**Level III Site Plan Application, 218-220 Washington Avenue, LLC**  
**218-220 Washington Ave, Tax Map 10, Block A, Lot 10 & 15**

This letter, associated materials and the enclosed plans are provided in response to the Level III Site Plan Application engineering review comments for 218-220 Washington Ave, the 45-unit residential condominium building off from Washington Avenue.

**City Planner Memorandum – Woodard & Curran Review Comments – Dated April 21, 2017:**

SUBSURFACE UNDERDRAINED SAND FILTER
NOT TO SCALE

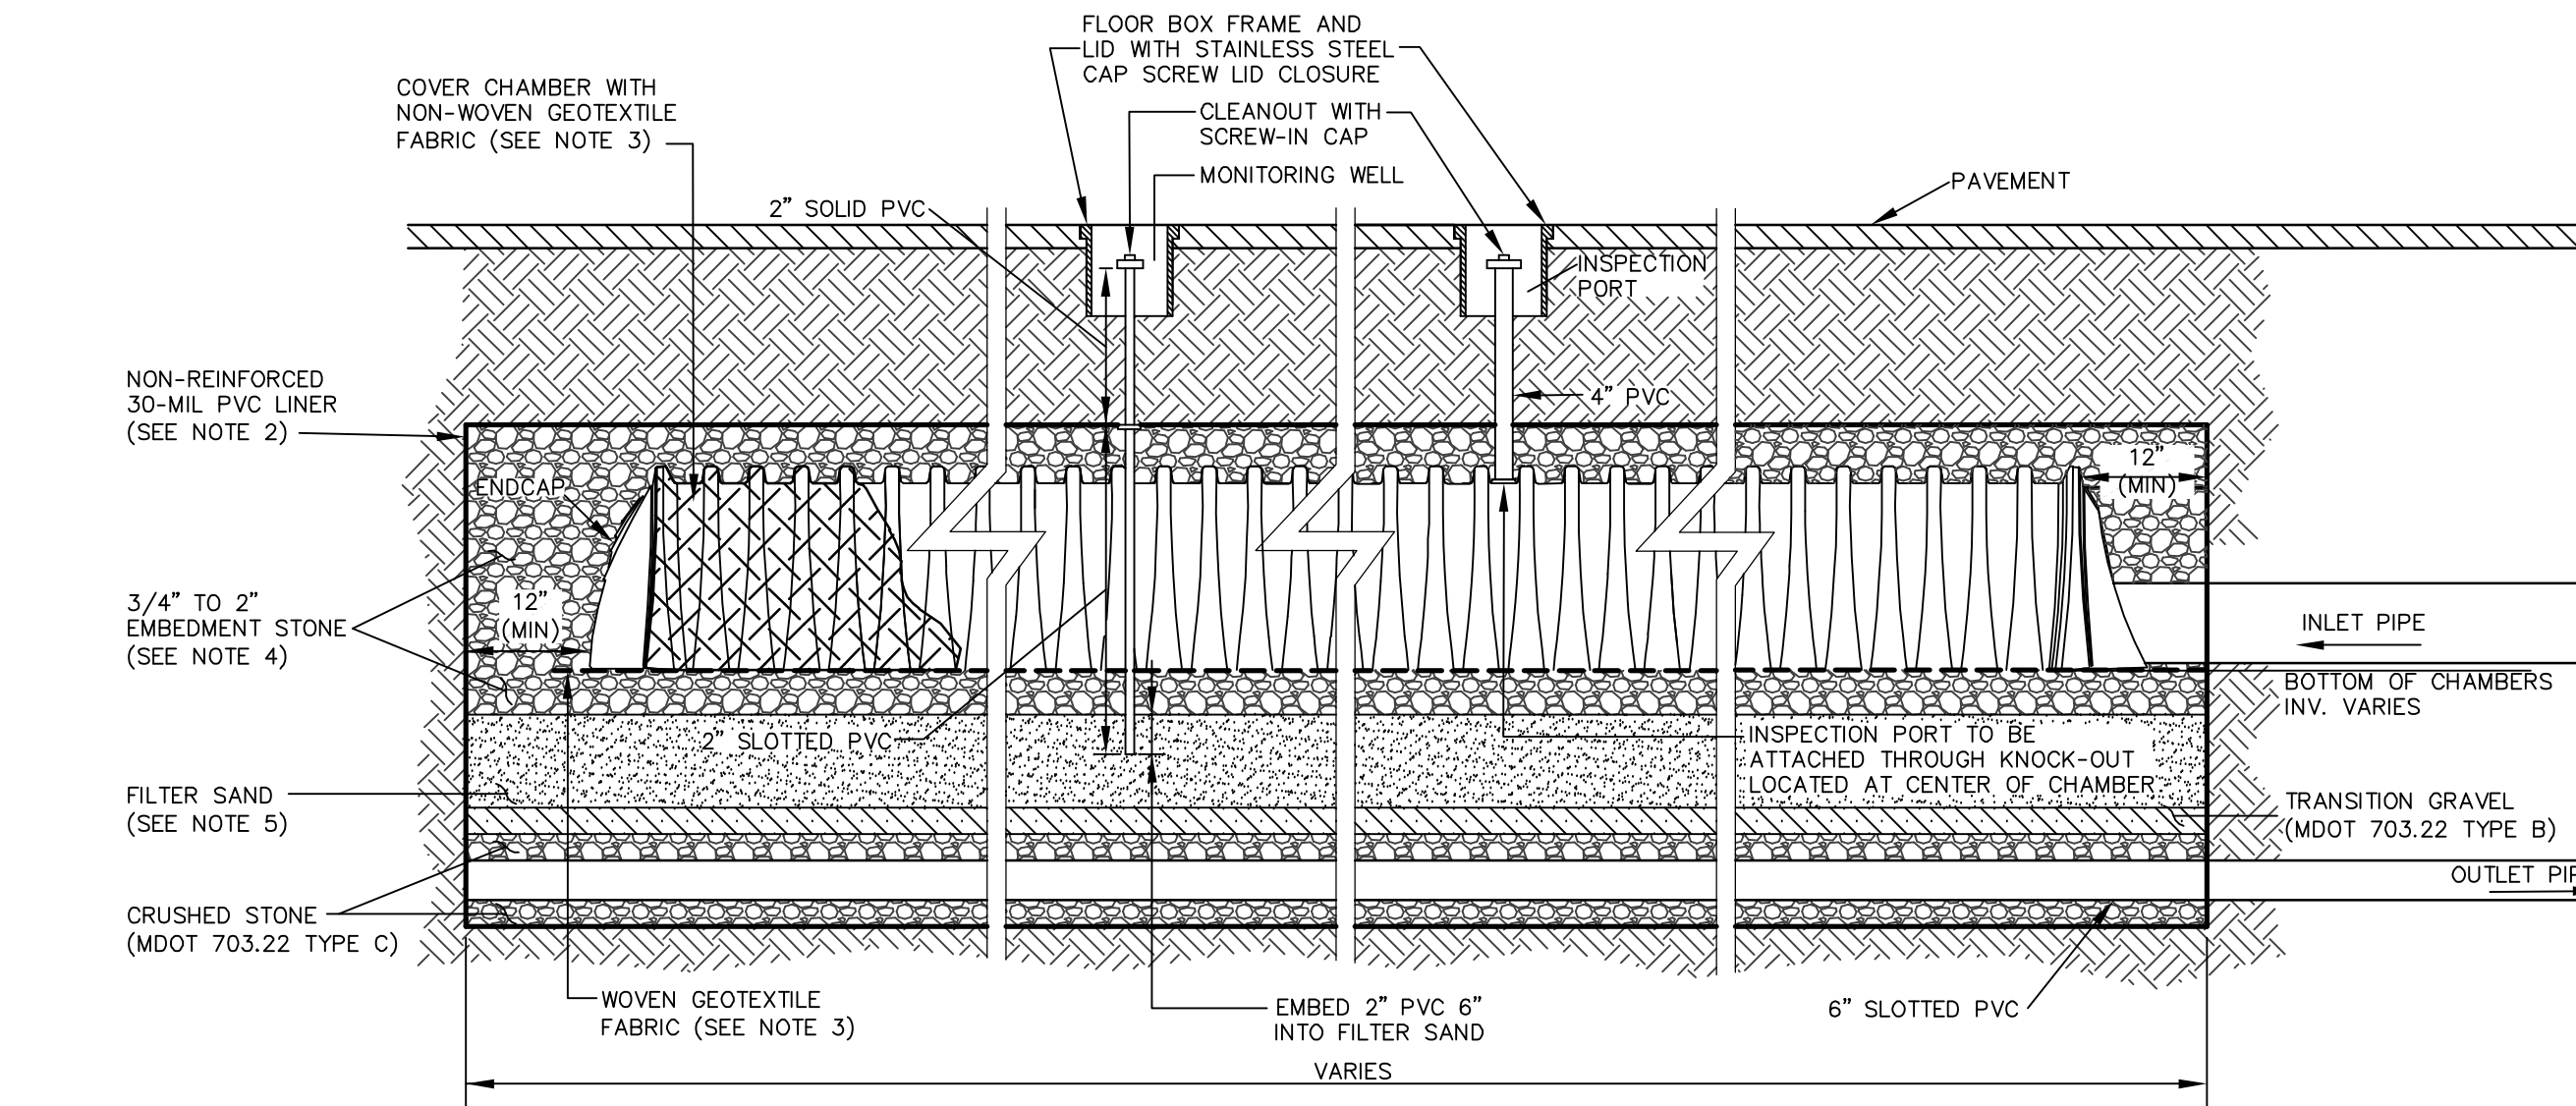
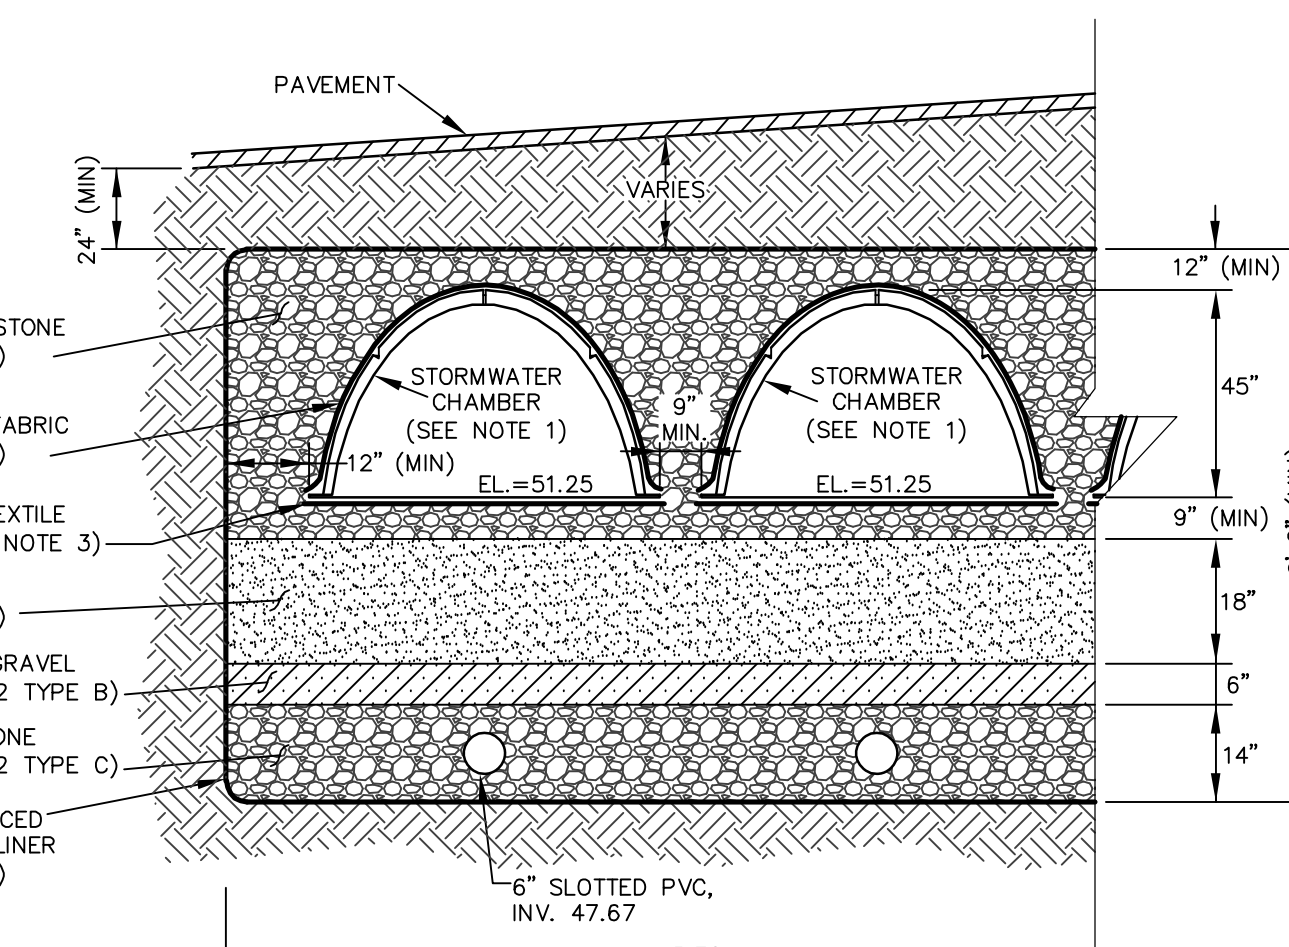
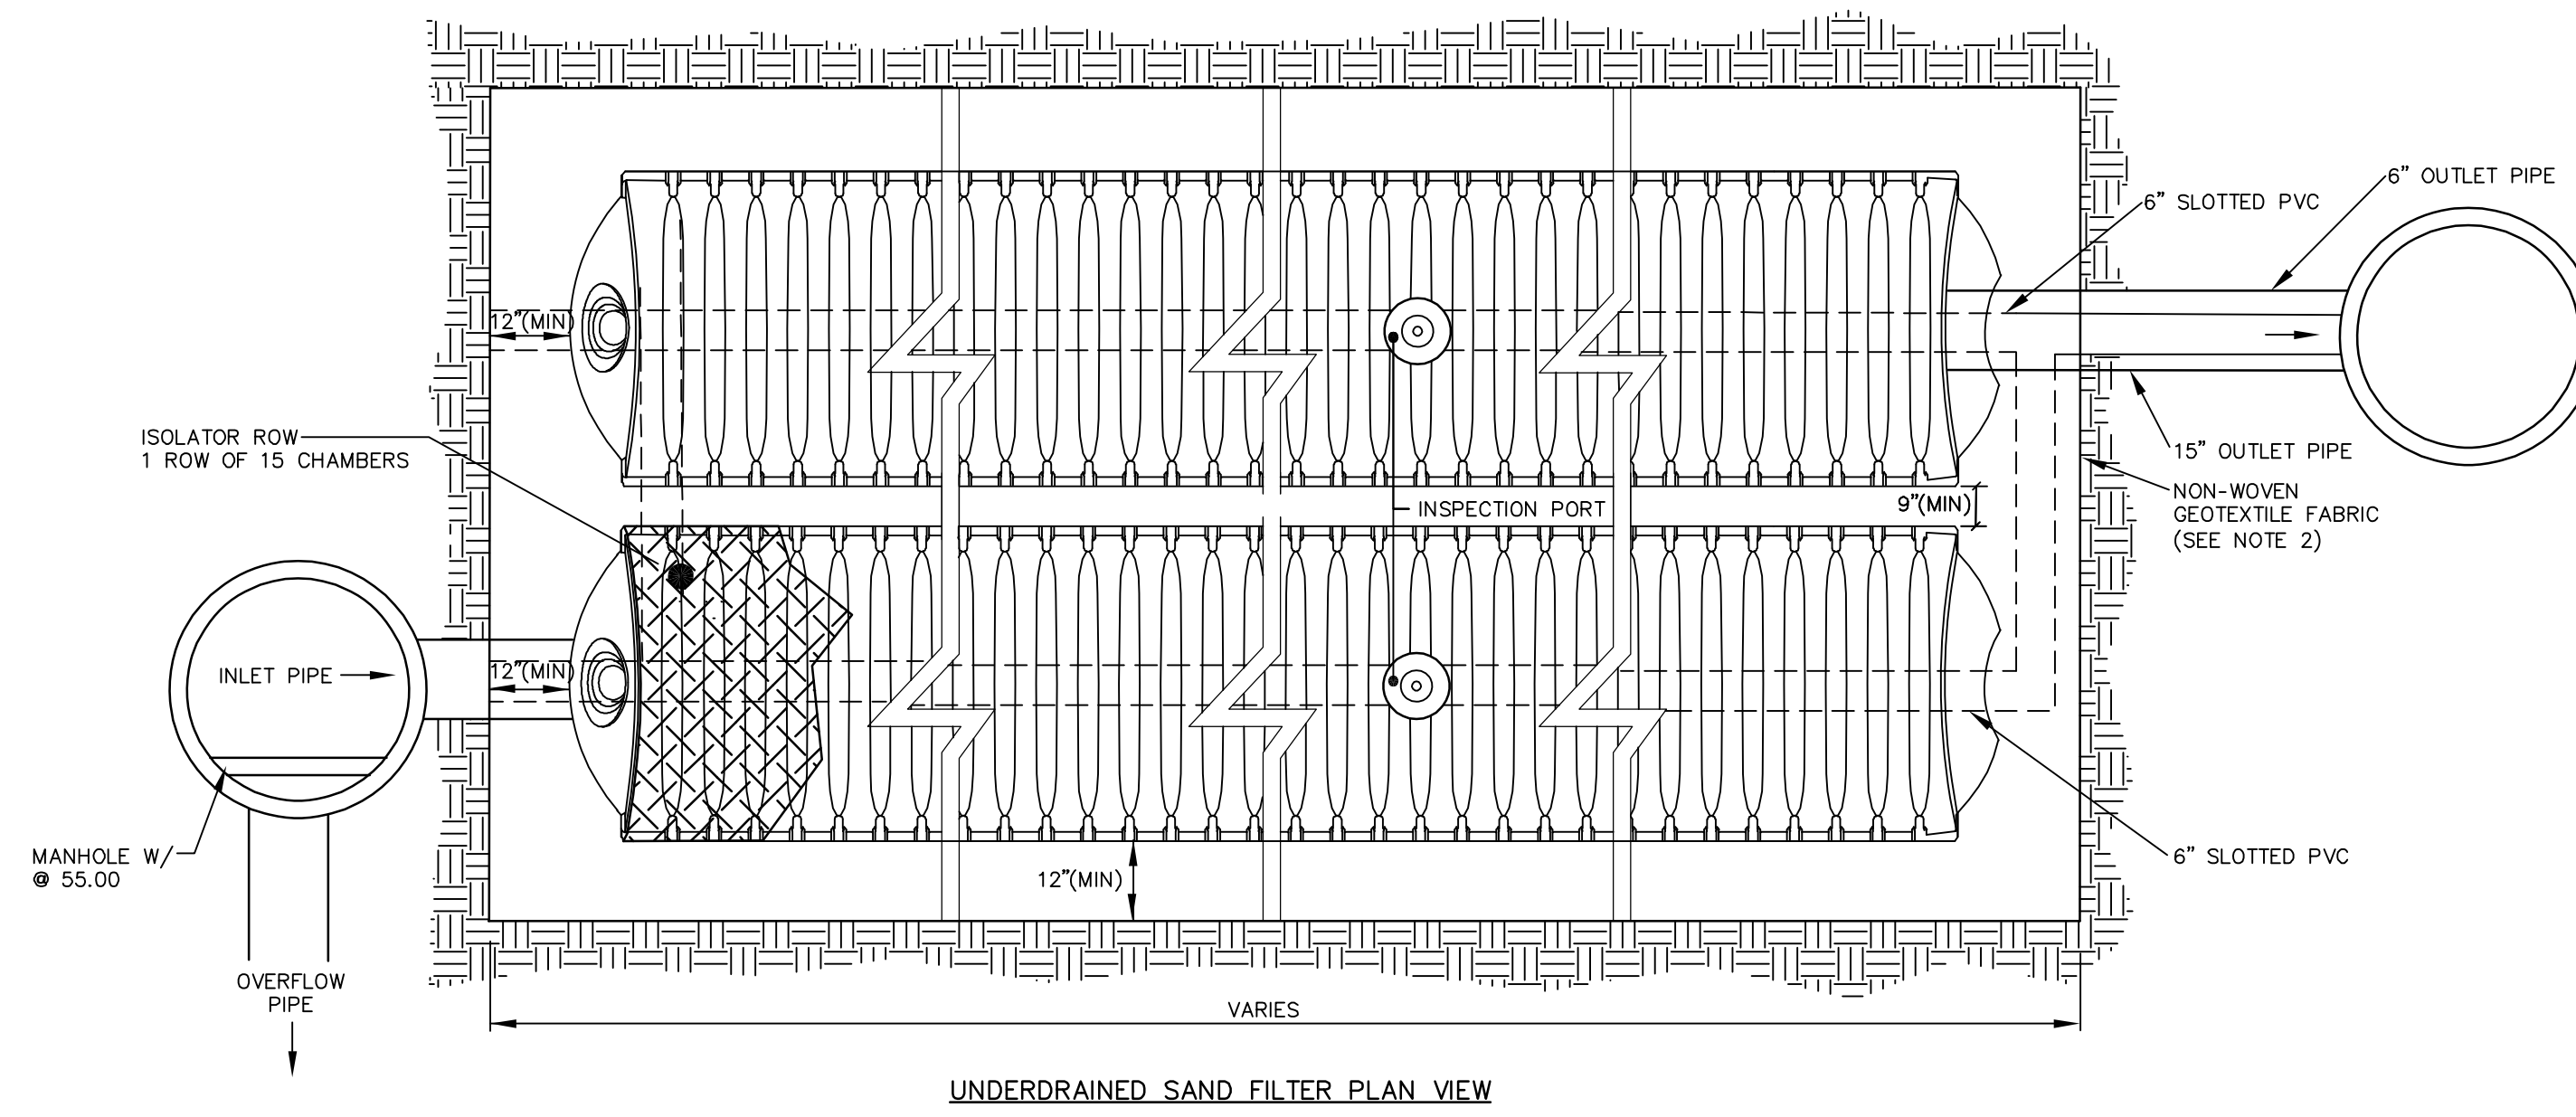
Underdrained Subsurface Sand Filter. The stormwater system is required to comply with the requirements of Chapter 7.3 of Volume III of the MaineDEP Stormwater BMP Manual. In general, we are in agreement with the stormwater management approach. We recommend that the applicant review the project layout with the Stormtech manufacturer to ensure that the design is in conformance with the manufacturer's standards. The Applicant should confirm that adequate access for maintenance will be provided. We are completing further review of the stormwater model, and will provide additional comments following the workshop.

- The engineering support team from Stormtech has reviewed the layout/design to ensure sizing and conformance. We will continue to coordinate with Mr. Cheever from Advanced Drainage Systems throughout the design process. The access manholes are located in the garage which can be accessed by a maintenance vehicle and/or small equipment.

CONCRETE ANCHORS FOR STEEPLY SLOPED PIPES INSTALLATION
NOT TO SCALE

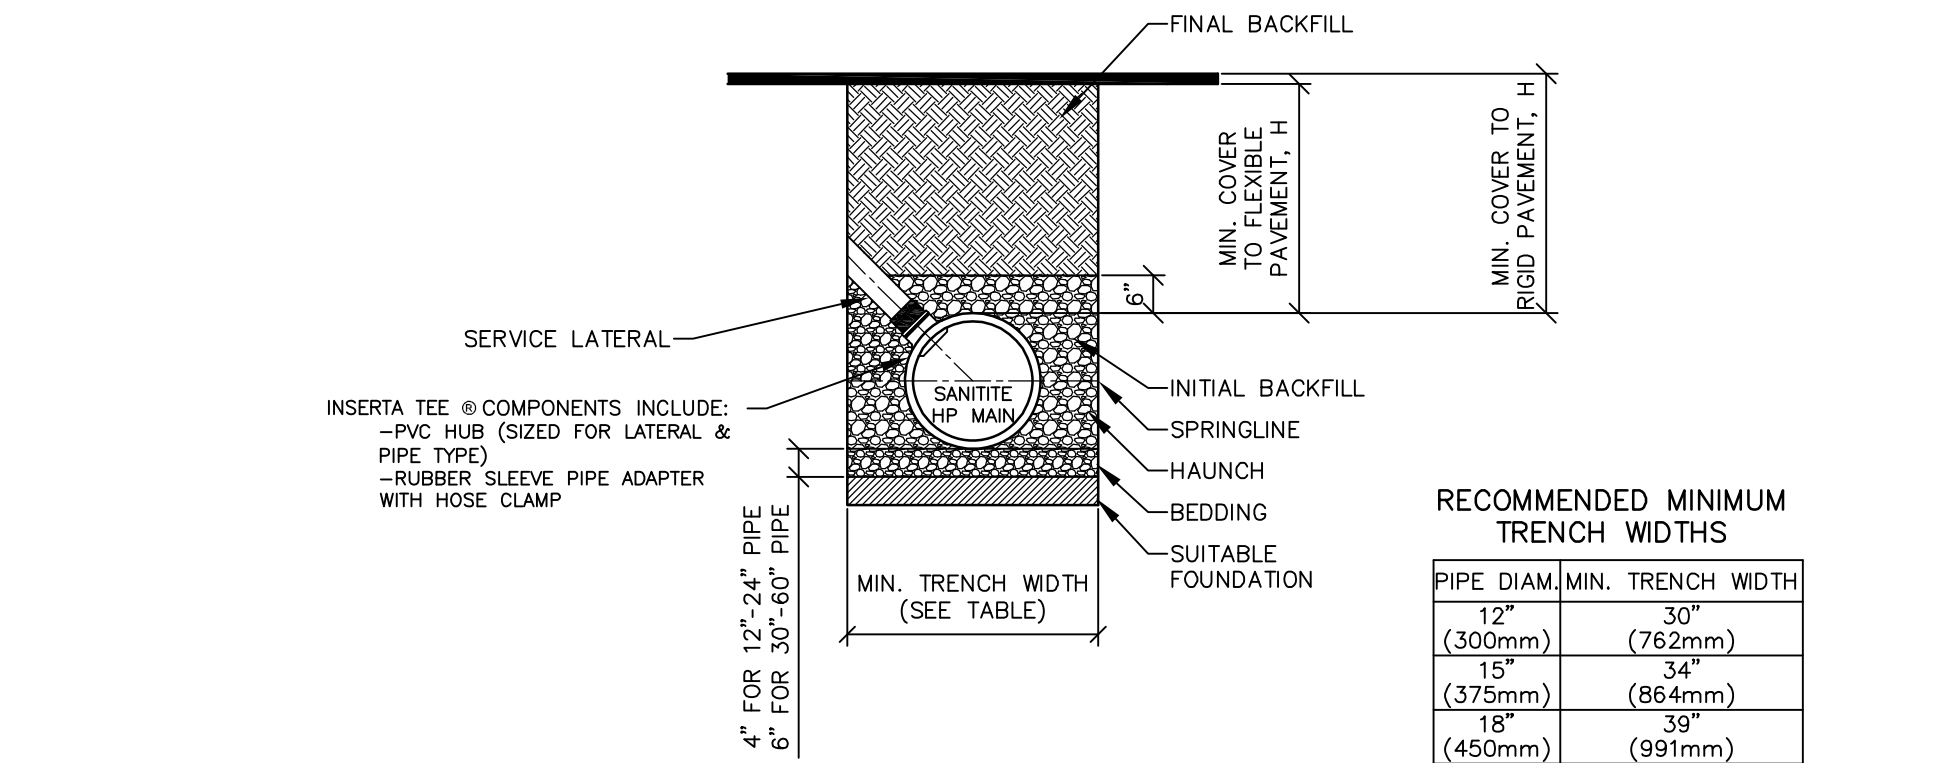
- 5) Relative to the depths discussed above, pipes will also be installed with steep slopes. The Applicant should address concerns associated with steep slopes (internal pipe scour, trench backfill erosion, etc.).

- The maximum slope of the proposed stormdrain installation is approximately 12 percent which flows at around 9 fps on a hundred year storm event. Based upon a recommendation from engineering at Advanced Drainage Systems, HP Storm (polypropylene) pipe is proposed, which has a higher pipe stiffness and superior joint performance. We have also specified concrete anchoring used for steep slope installation to ensure pipe stability and reduce the potential trench erosion.

TYPICAL REINFORCED WALL SECTION
NOT TO SCALE

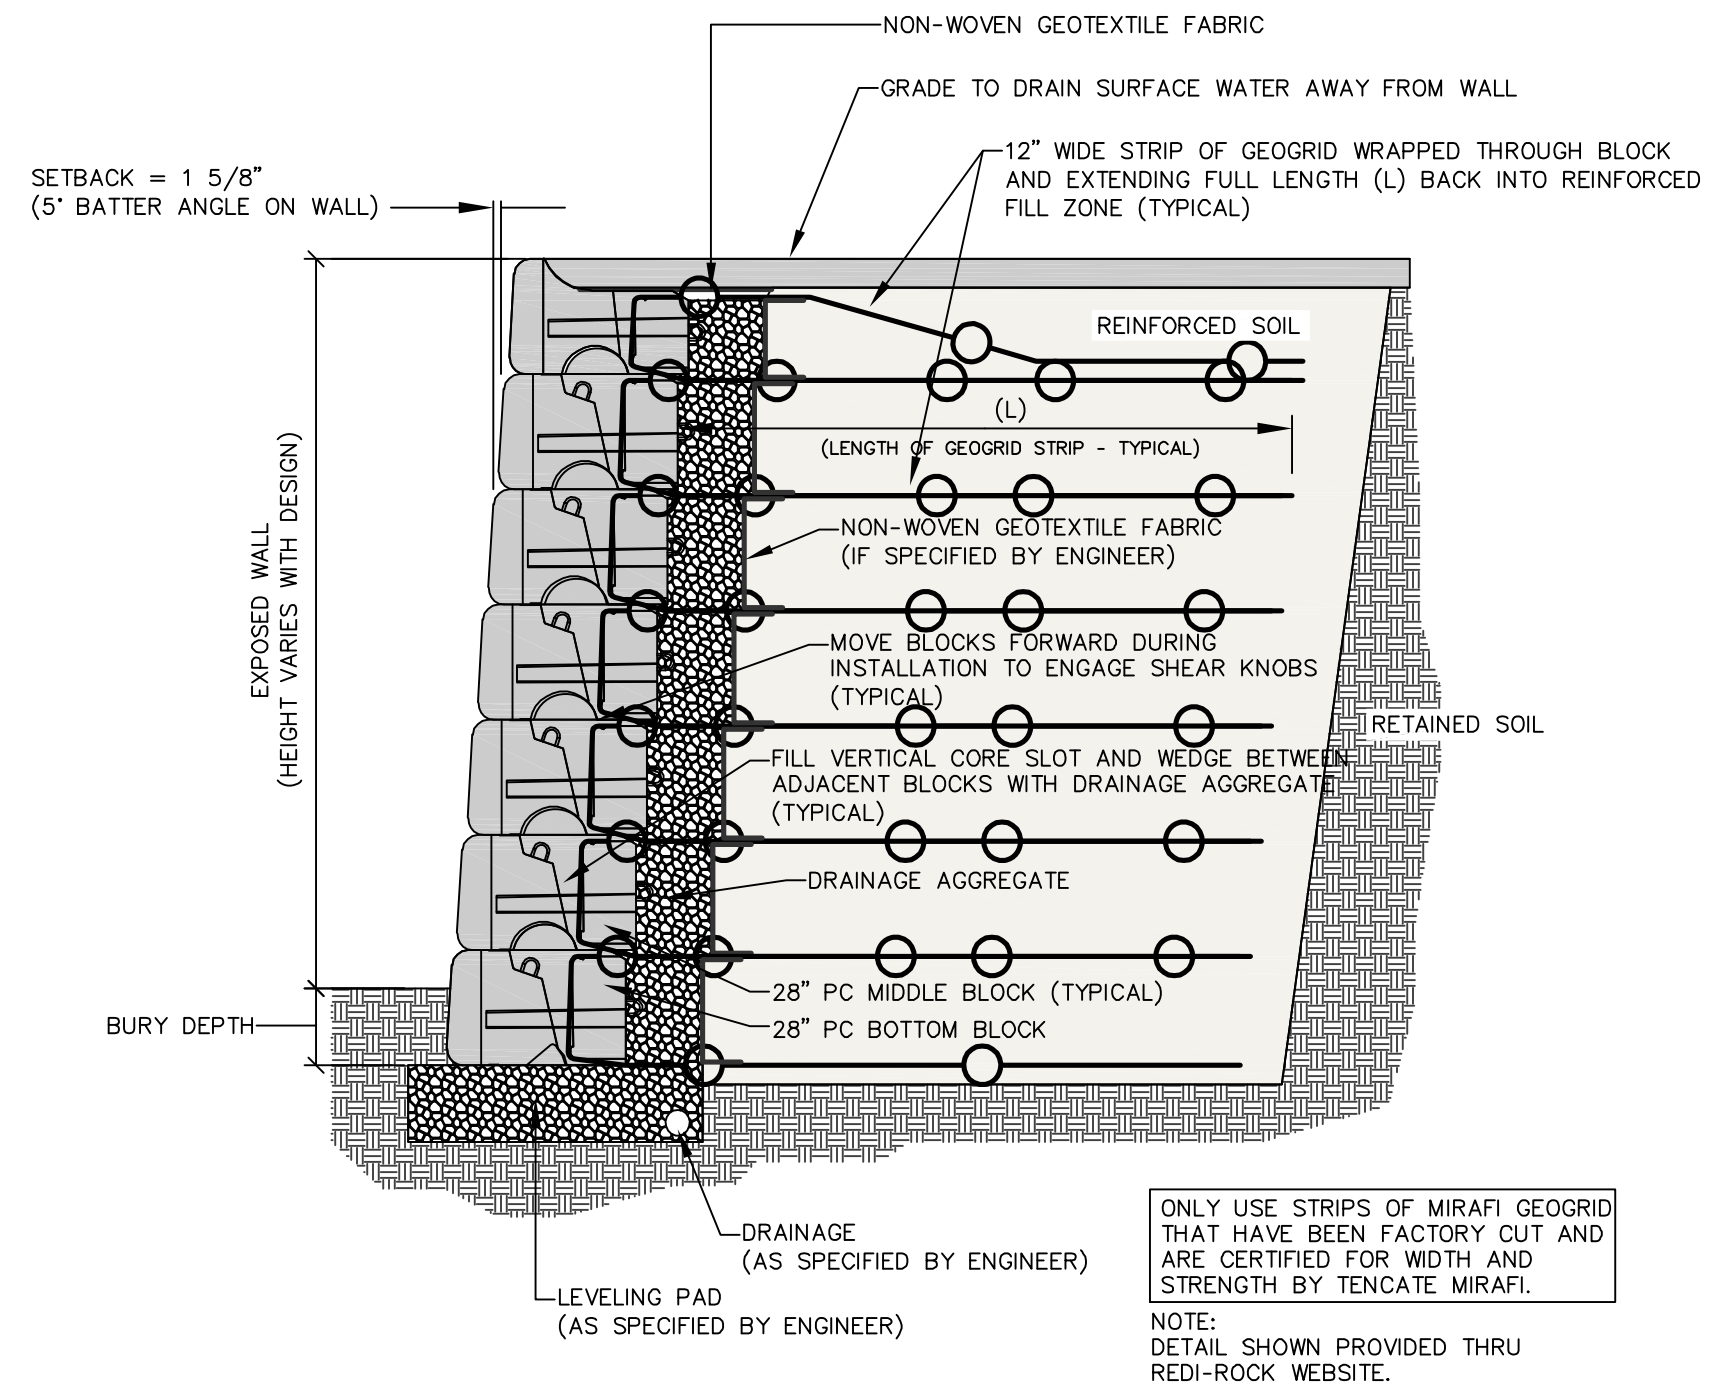
- Additional geotechnical information will be provided as part of the wall design.
